**RE: Panda Express at 2040 Gibson Blvd SE (Lot C-2 Lovelace Heights Addition.)
Erosion and Sediment Control Plan
Engineer's Stamp date 03/5/2025 (M15E021F) SWQ-2025-00012**

Civil Engineering Services, PC (CES) is in receipt of your comments, from March 11, 2025. Below are our responses to your comments. Please include this document in your review of the proposed plans.

C06.0

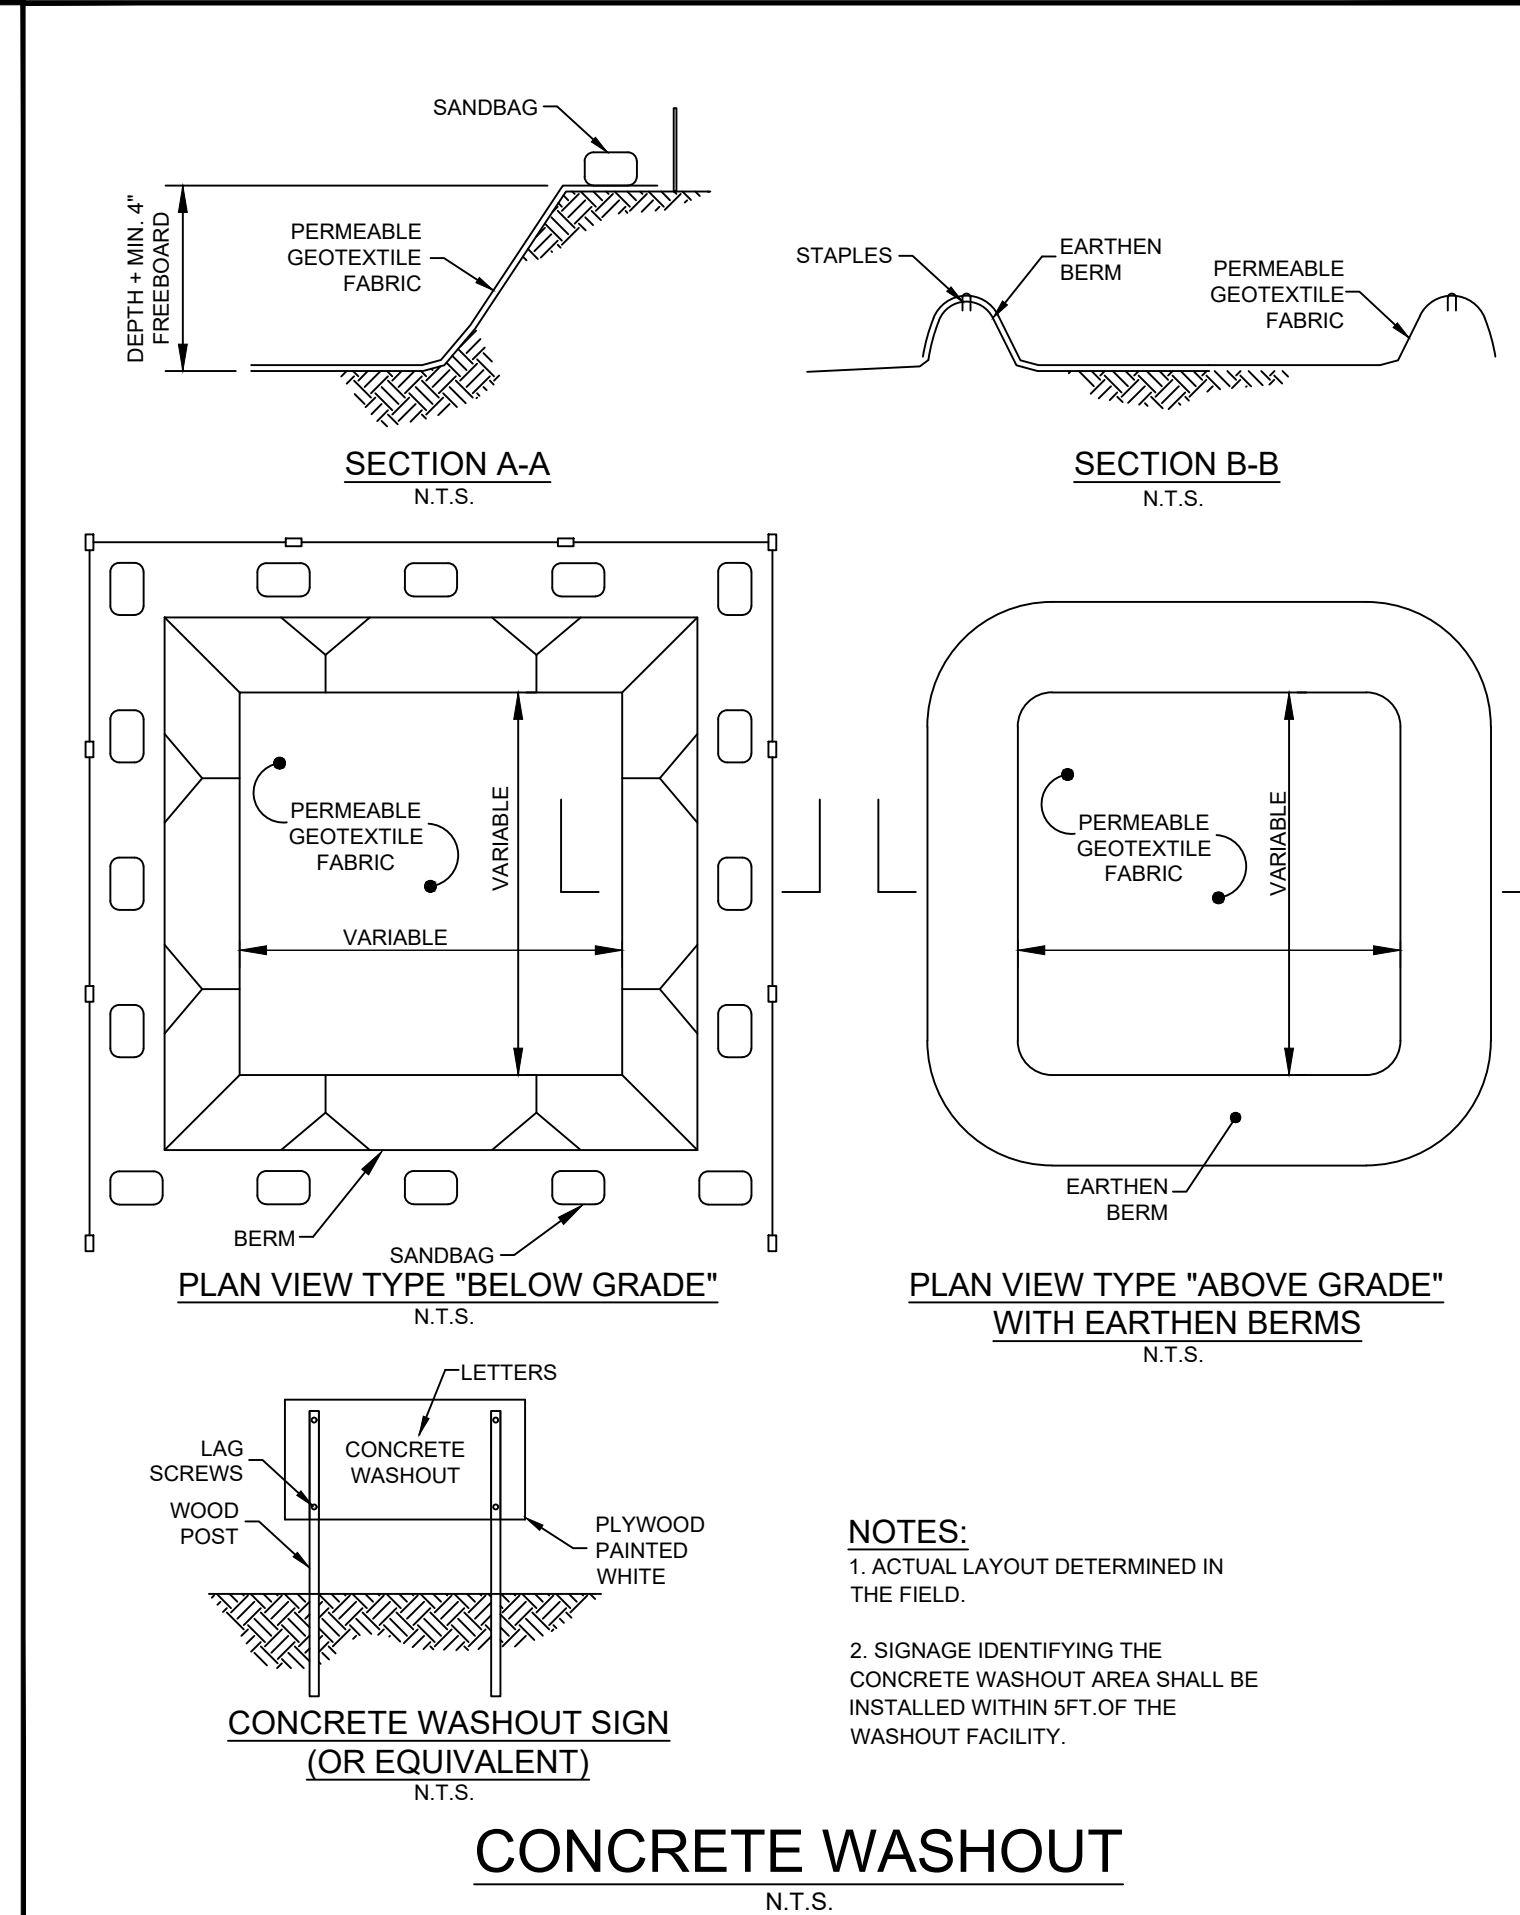
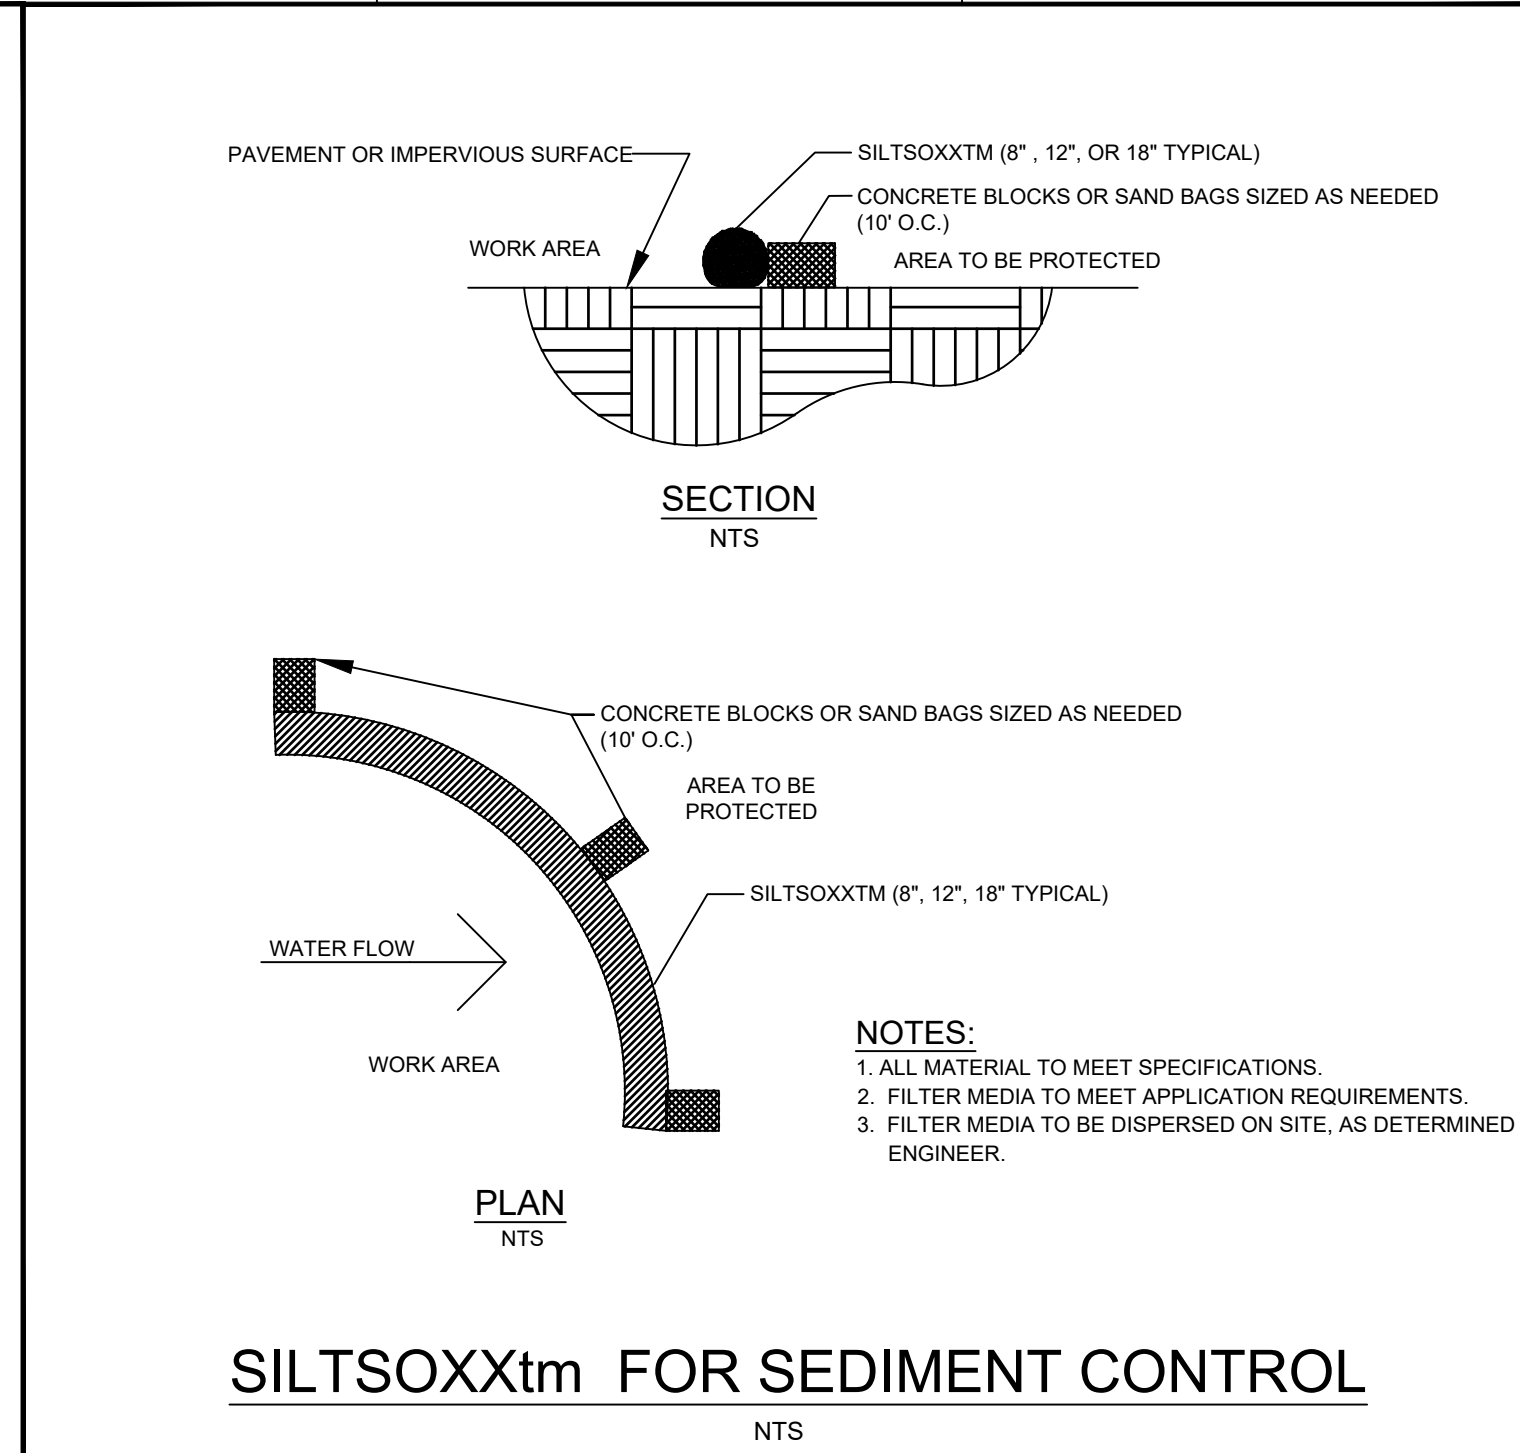
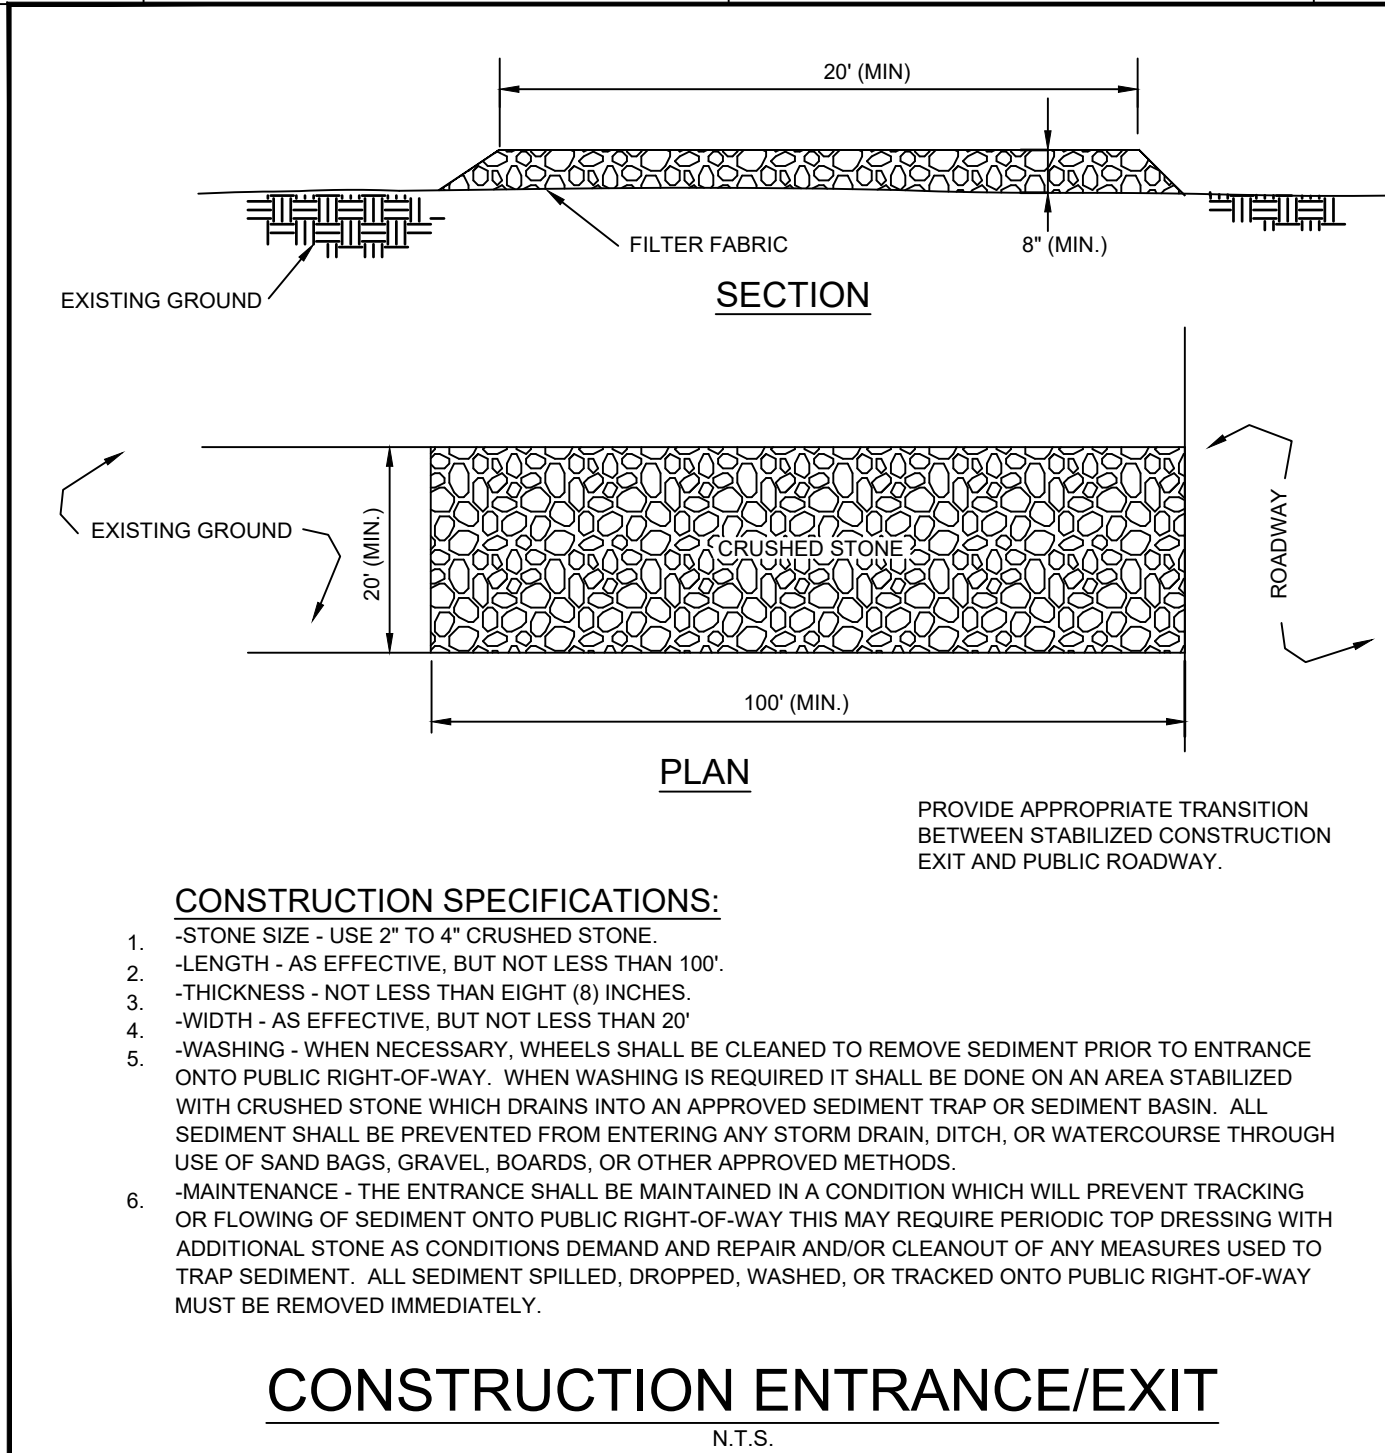
1. This site is part of a Common Plan of Development or Sale (CPODS) larger than 5 acres, so permit coverage is required for this site regardless of its size. It's not eligible for any waivers, and the BMP selection must be made based on the use of appropriate soil loss prediction models (i.e., SEDCAD, RUSLE, SEDIMOT, MULTISED, etc.) OR equivalent generally accepted (by professional erosion control specialists) soil loss prediction tools per Part 9.6.1.C.i of the Construction General Permit (CGP) requirements. The soil loss prediction model is missing from the SWPPP, and the Soils are not identified in the ESC Plan. You must add a soil loss prediction model to the SWPPP, showing that the BMPs will prevent soil loss. You must also add a table with name type, particle sizes, and erodibility factor (CGP 2.1.1) to the ESC Plan. **The soil table was missing from the ESC Plan, and ESC Plan sheet C06.0 was missing from the resubmittal. Sheet C06.1 is the only sheet in the resubmittal. The soil loss prediction model should show that before the commencement of construction activities, this site was paved and had no sediment discharge, so ponds will be required to prevent sediment discharge during construction.**

5. The limits of land disturbing activities must include all stockpiles and construction support activities already taking place on the adjacent property, Lot C-1. Also, indicate the areas of control of the two property owners/operators unless all construction support activities are removed from Lot C-1 and the disturbed portions are stabilized with rock per CGP 2.2.14.c.ii before the next City Inspection. **The ESC Plan, Sheet C06.0, was missing from the resubmittal, so the limits of disturbance are unknown.**

6. The BMPs shown are inadequate. Mulch sock, as shown, isn't an acceptable substitute for Silt Fence. Silt Fence must be shown at the limits of disturbance, including the area of construction support activities and offsite stockpile as a dust control per your Fugitive Dust Permit and CGP 2.2.6. However, Silt Fence alone isn't sufficient to manage the stormwater quality requirements where the silt fence is downhill from disturbed areas, and the Silt Fence isn't located on-contour or the Silt Fence is located at concentrated "Discharge Points." You must identify the Discharge Points on the ESC Plan and add Sediment Traps, one each at the southwest and northwest corners of the site. At all locations downhill from disturbed portions of the site where the Silt Fence isn't on contour, you must add Diversion Berms in addition to the Silt Fence. **The ESC Plan, Sheet C06.0, was missing from the resubmittal, so the controls are unknown.**

Response: ESC Plan Identifies soils and table added, ESC plan now contains sediment traps see keynote 10 and sediment trap note on sheet C06.0. SWPPP contains soil loss prediction model.

Response: Stockpile location added to plan, stockpile on Lot C-1 has been removed.

Response: Silt fence added at limits of disturbance, See Keynote 5. Discharge points located on plans see keynote 8. Sediment trap is not required for disturbance under 5 acres per CGP 2.2.12. Diversion Dike added see keynote 7.

Response: See Landscape plan attached. Section 7 added to ESC. Aggregate added to offsite grading see keynote 11 on sheet C06.0 and detail 1013-SKL-1 on Sheet C06.1
